**KIRKLEES METROPOLITAN COUNCIL
INVESTMENT & REGENERATION SERVICE**

**DELEGATED DECISION TO DETERMINE APPLICATIONS FOR
CONSENT, AGREEMENT OR APPROVAL REQUIRED BY CONDITION**

Reference No:	2023/44/92092/E
Site Address:	Blue Hills Farm, Whitehall Road West, Birkenshaw, BD11 2DU
Description:	Discharge of condition 5 (new retaining walls) of previous reserved matters approval 2022/91047 for a development of 91 dwellings, pursuant to outline permission 2019/90527 (for erection of up to 127 dwellings, with details of access)
Recommending Officer:	Ellie Thornhill

DECISION – Discharge of Condition – Refuse

TITLE
 Countryside Partnerships
 Blue Hills Farm Estates
 Redi-Rock Wall Design
 3.36m

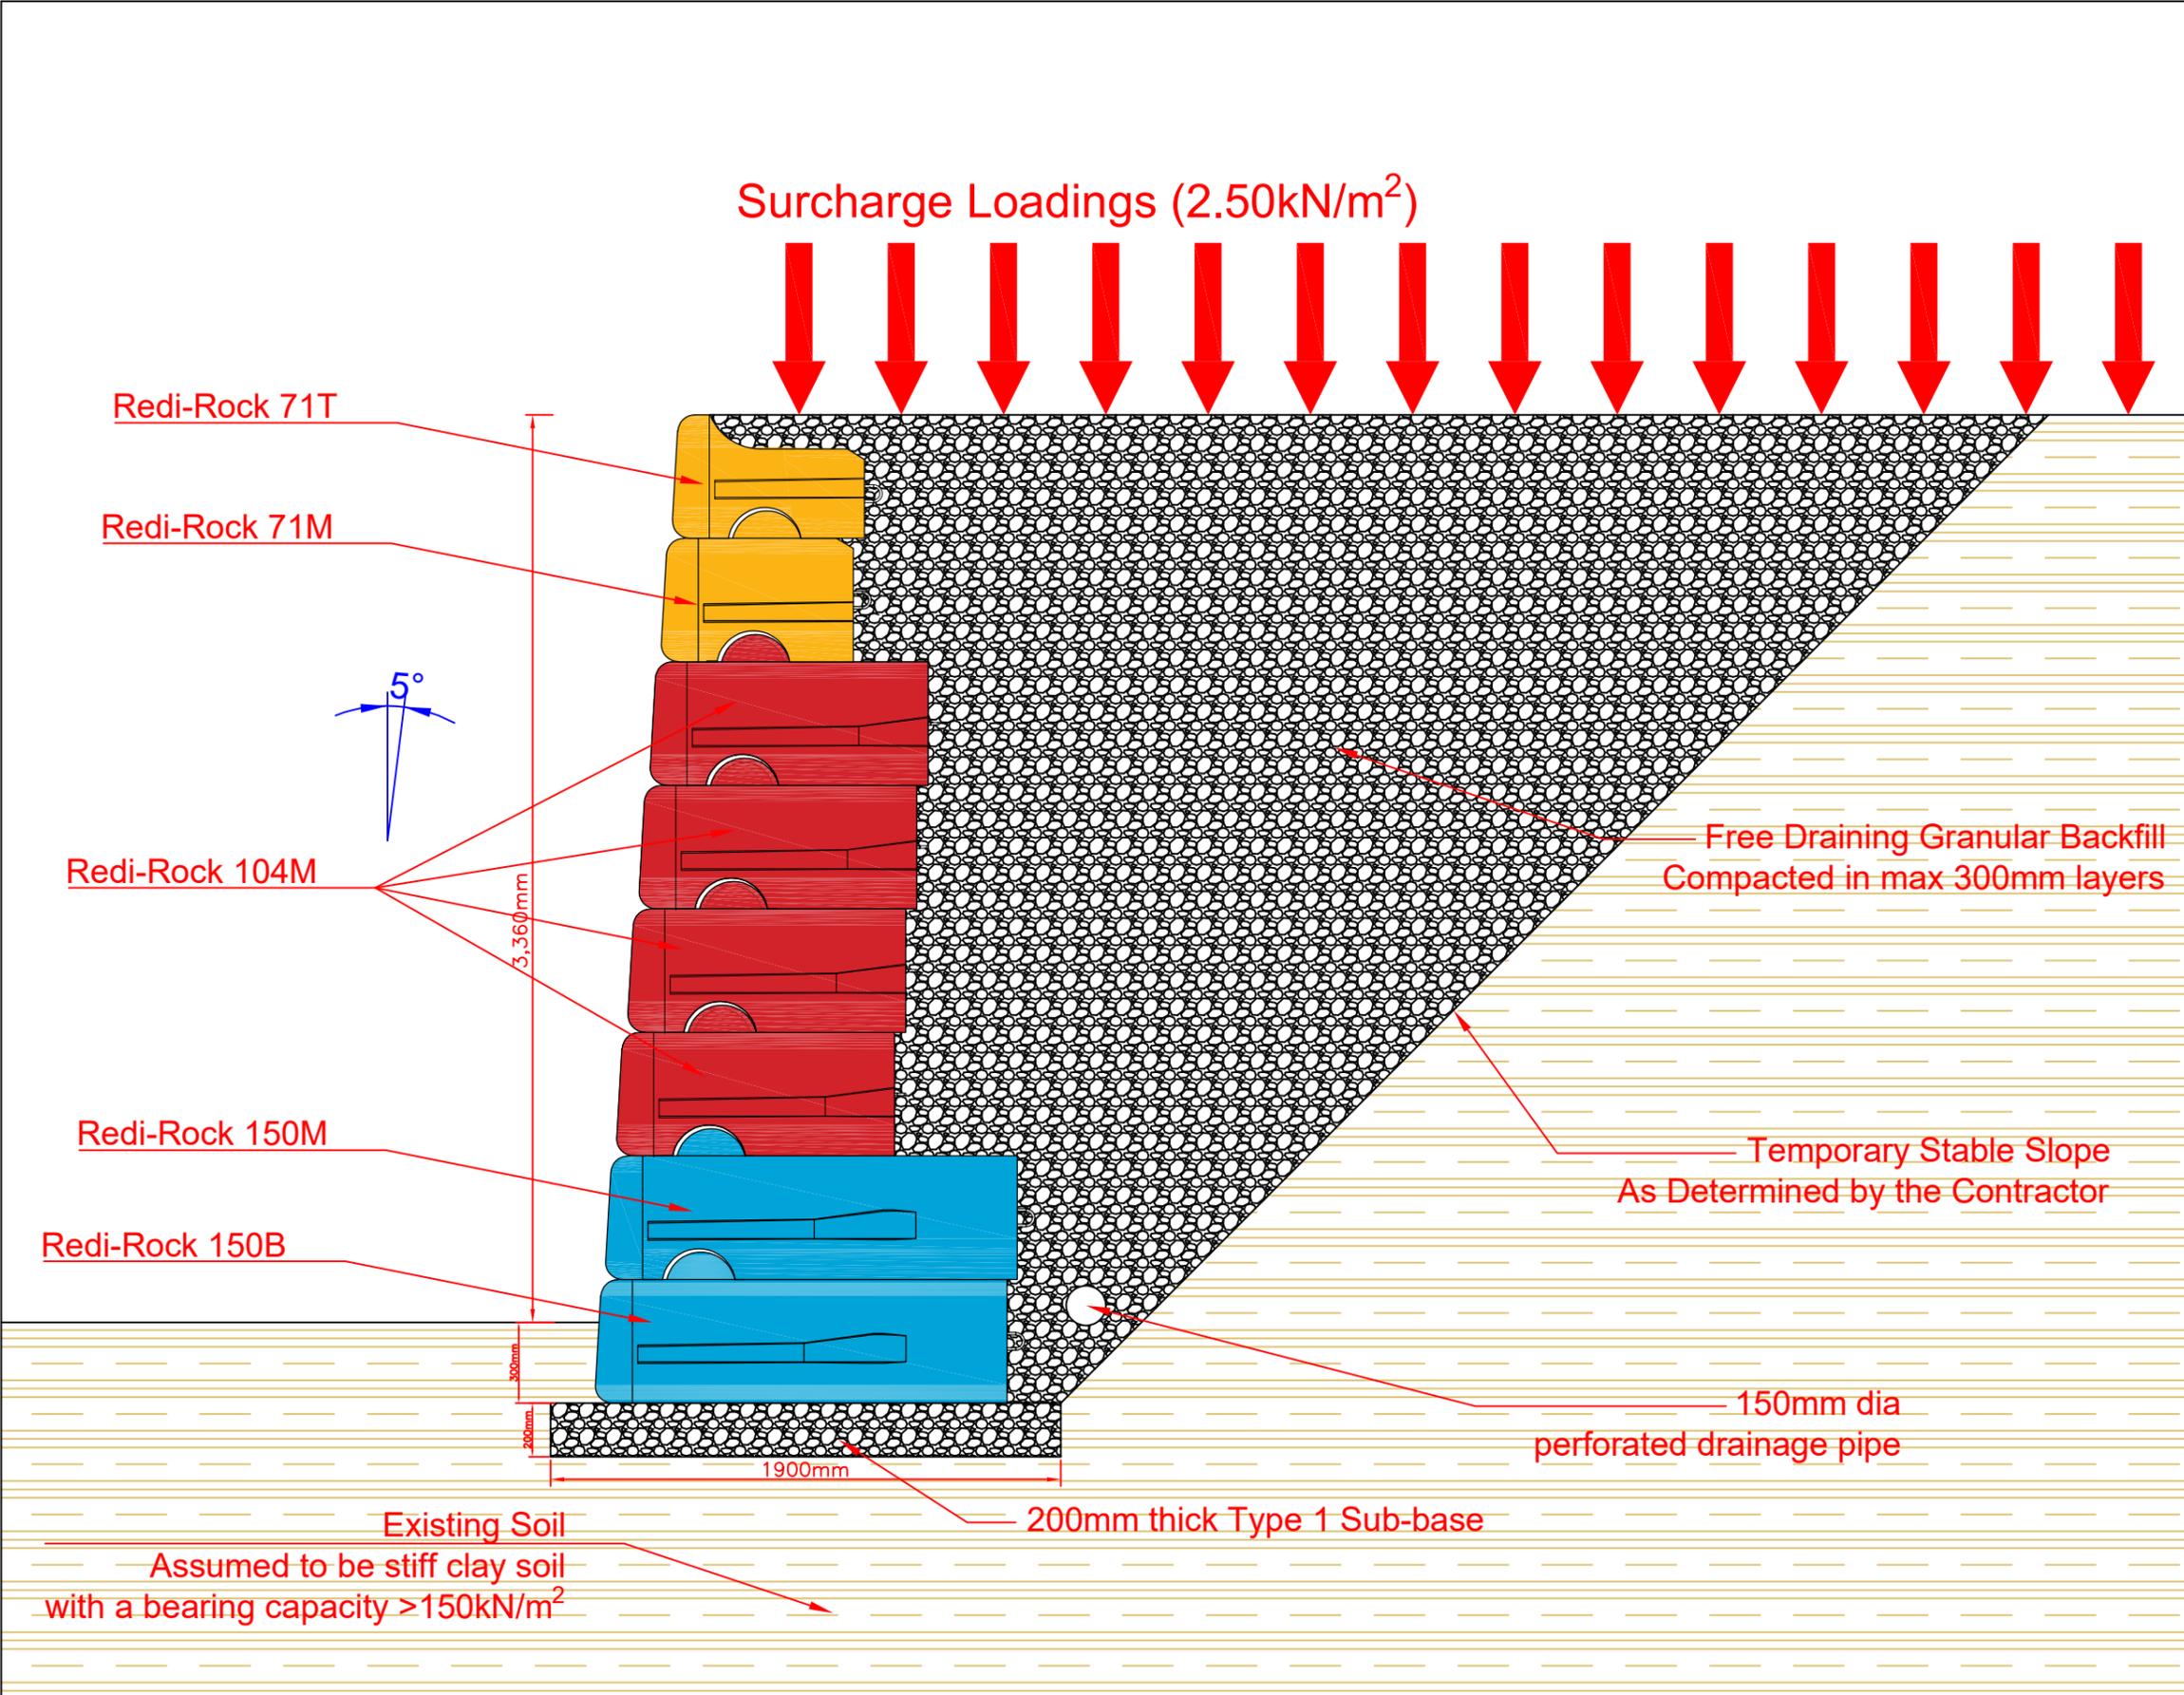
However, from a visual perspective, officers are concerned regarding the design and height of the retaining wall. The specification provided shows the wall to be constructed using a RediRock (grey concrete blocks) retaining wall product.

The wall as built does not appear in keeping with the surrounding character and appearance. Nearby boundary treatments include natural stone walls, soft landscaping, low timber railing, and (at one corner of the nearby roundabout) a short section of natural stone blocks. The wall as built also differs to the materials used in the elevations of nearby buildings.

Furthermore, the height of the wall varies from 1.6m to 3.8m, with no clear justification provided to explain this, other than the site levels have been heavily influenced by highway requirements. Creating acceptable private amenity space is not considered to be a suitable justification for the height of the wall, given that gardens can be slightly sloped and still be useable. The wall – particularly its southern corner which is the first thing seen at this key (main road) entry point to Birkenshaw – is visually obtrusive and overdominant, and gives the development an inappropriate, fortified appearance. Furthermore, it prevents the development from engaging with and animating the road, and as a result the development effectively turns its back on the most important public realm it abuts. No boundary treatments of a similar height and length exist in the site's immediate vicinity.

Given the substantial height and stark appearance of the retaining wall, officers cannot support the design of this structure and therefore condition 5 cannot be discharged.

However, officers have significant concerns regarding the height and stark materials used for the retaining boundary wall, due to its prominence along the A58 and the fact that the area is characterised by lower boundary treatments which feature more appropriate materials.
